DELEGATED ITEM FILE REPORT - APPROVAL

Application No:	3/2013/0556/P
Development Proposed:	Single storey side (north) extension and single storey porch extension to the rear (east) at Rowan Garth, Stoneygate Lane, Knowle Green

East Elevation

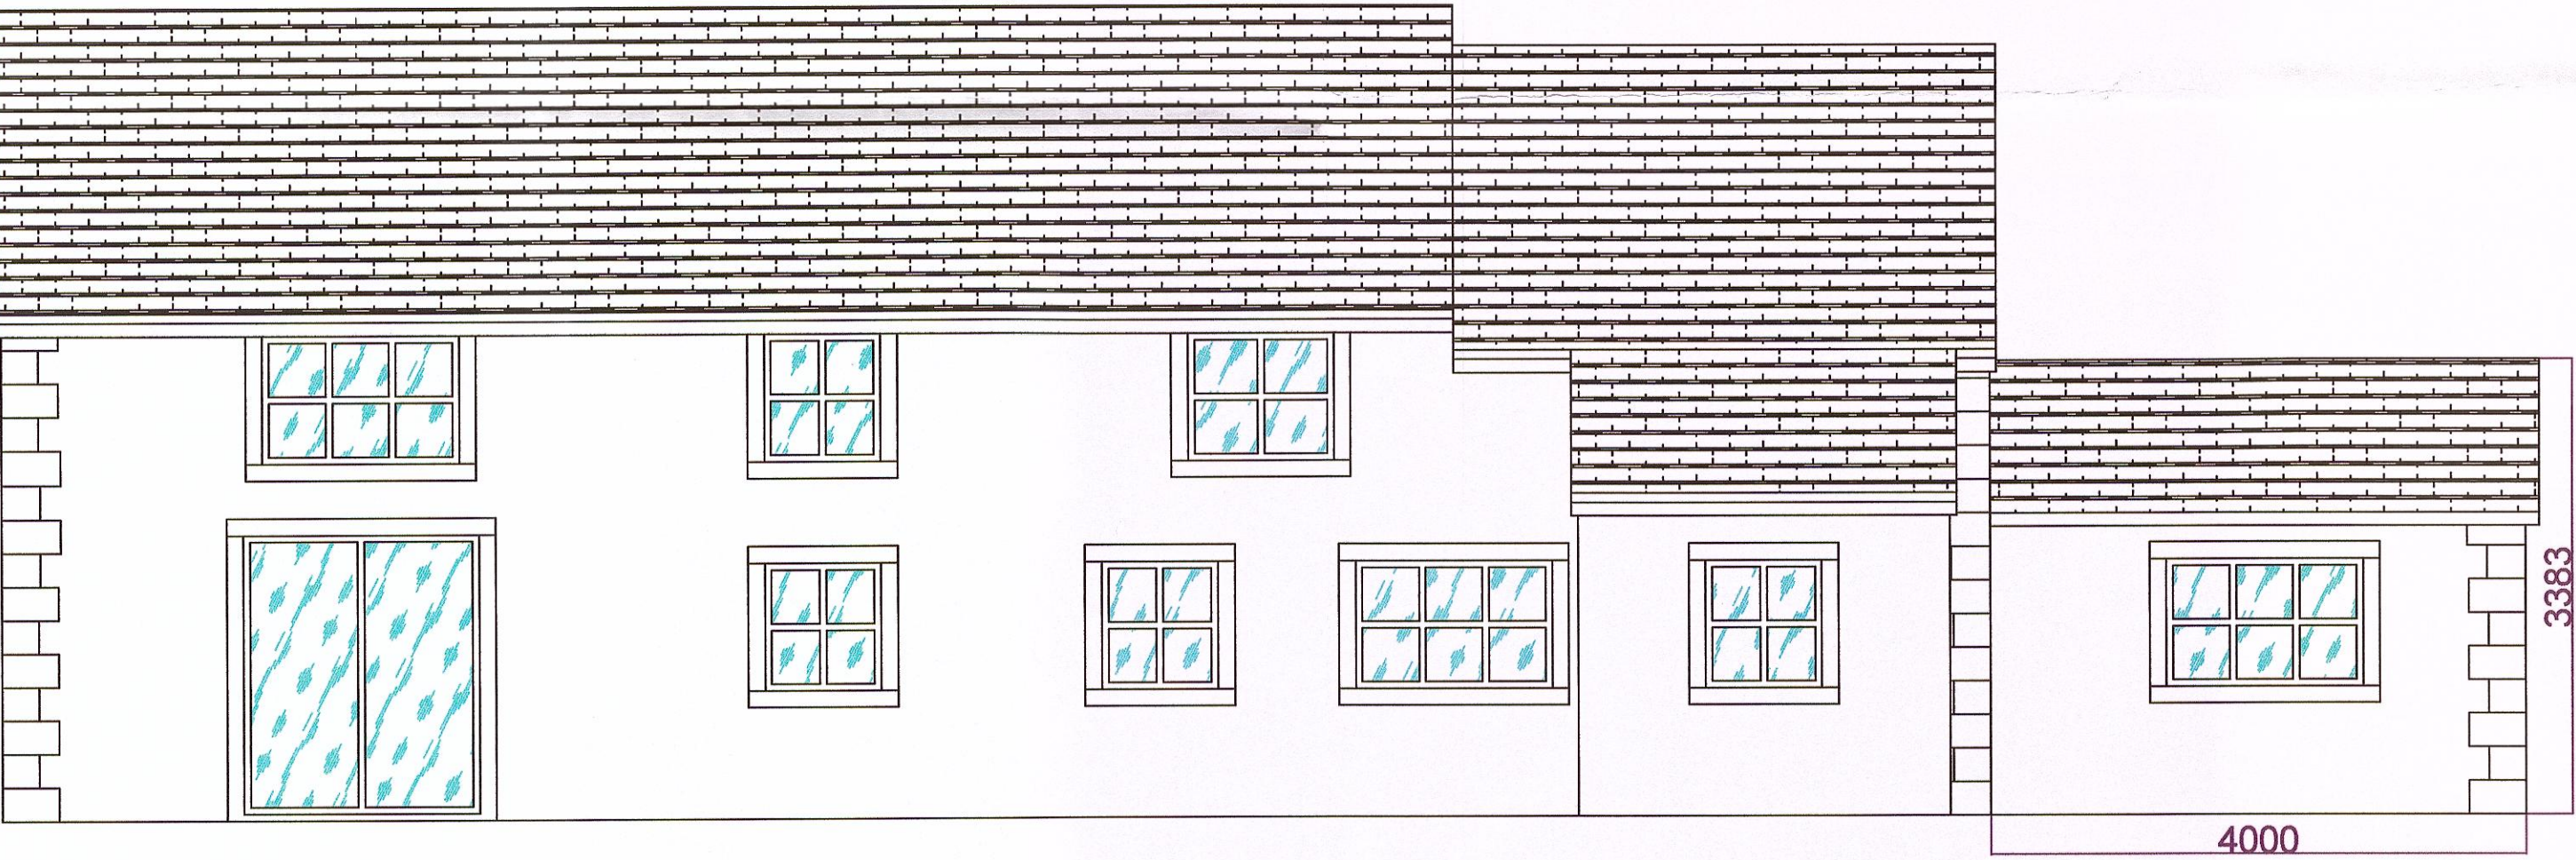
The proposed extension to the rear (east) is to measure 2.7m x 2.7m and built to an overall height of 3.4m. This element of the proposed development is to be utilised as a porch, being

constructed from rendered elevations under a slate cat slide roof.

Having regard to the impact the proposed development will have upon the character and setting of the existing dwelling, the proposed extensions would appear as subservient additions, by virtue of their design and scale in relation to the existing dwelling. In addition to this the proposed materials would correspond with those used in the existing dwelling. I am therefore satisfied that the proposals would not appear out of character in relation to the existing dwelling.

North Elevation

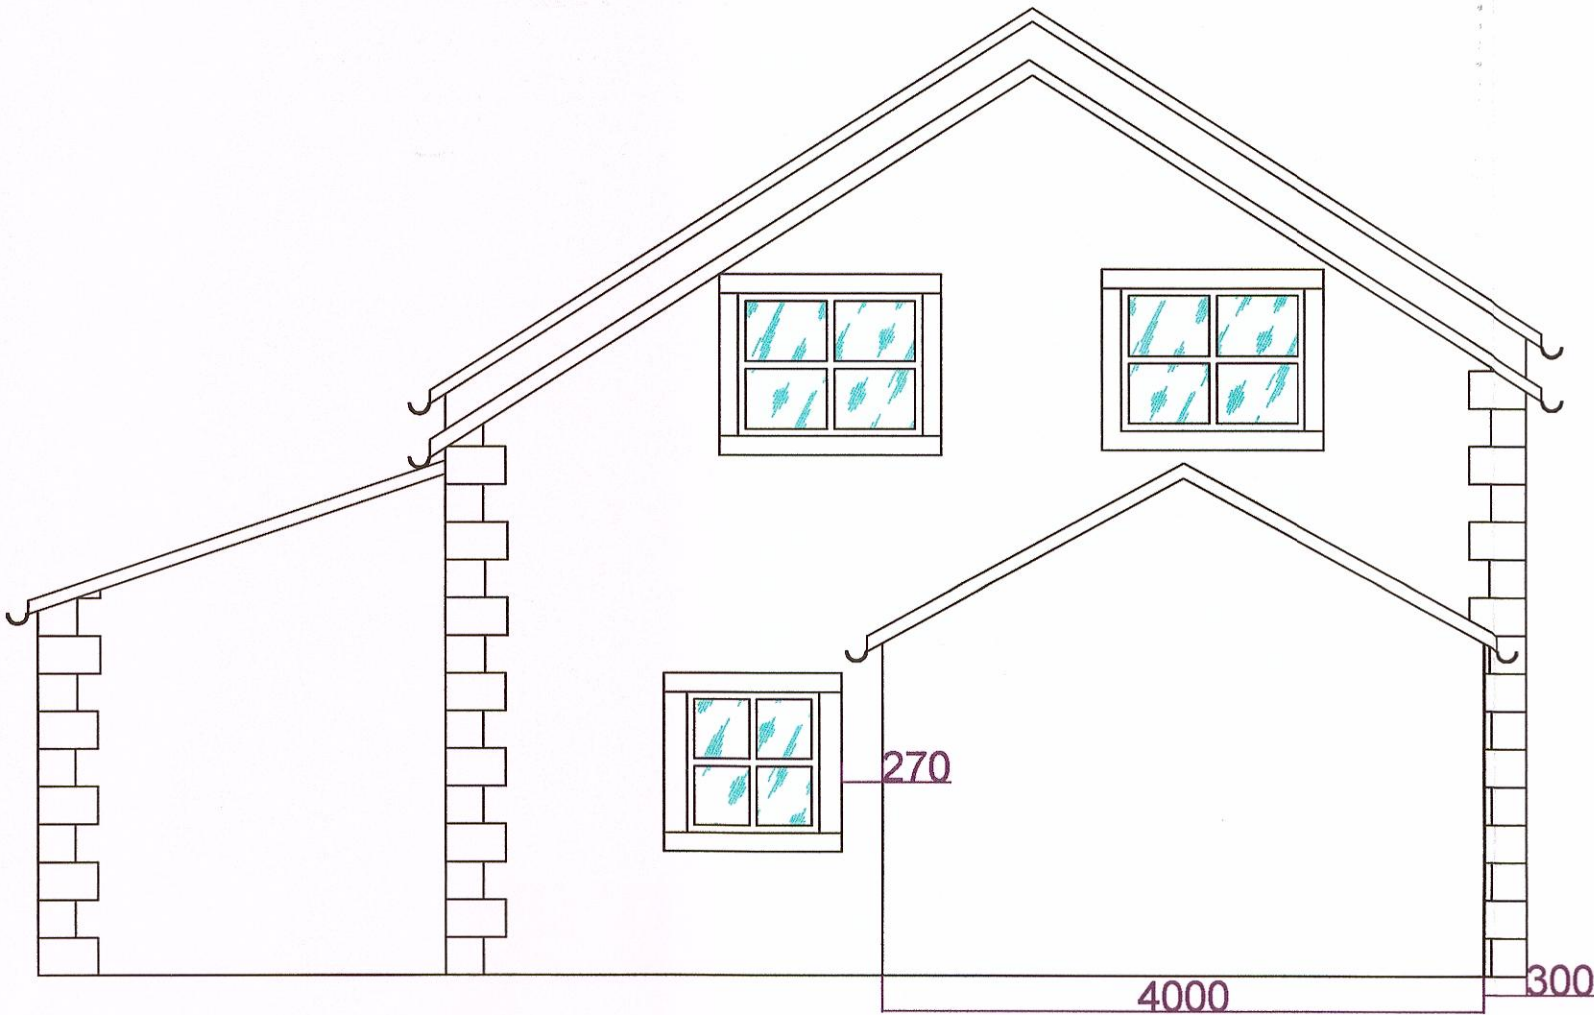
The proposed extension to the side (north) elevation is to measure 4m x 4m built to an overall height of 3.38m. The proposed structure is to be constructed from rendered and stone elevations under a dual pitched slate roof.
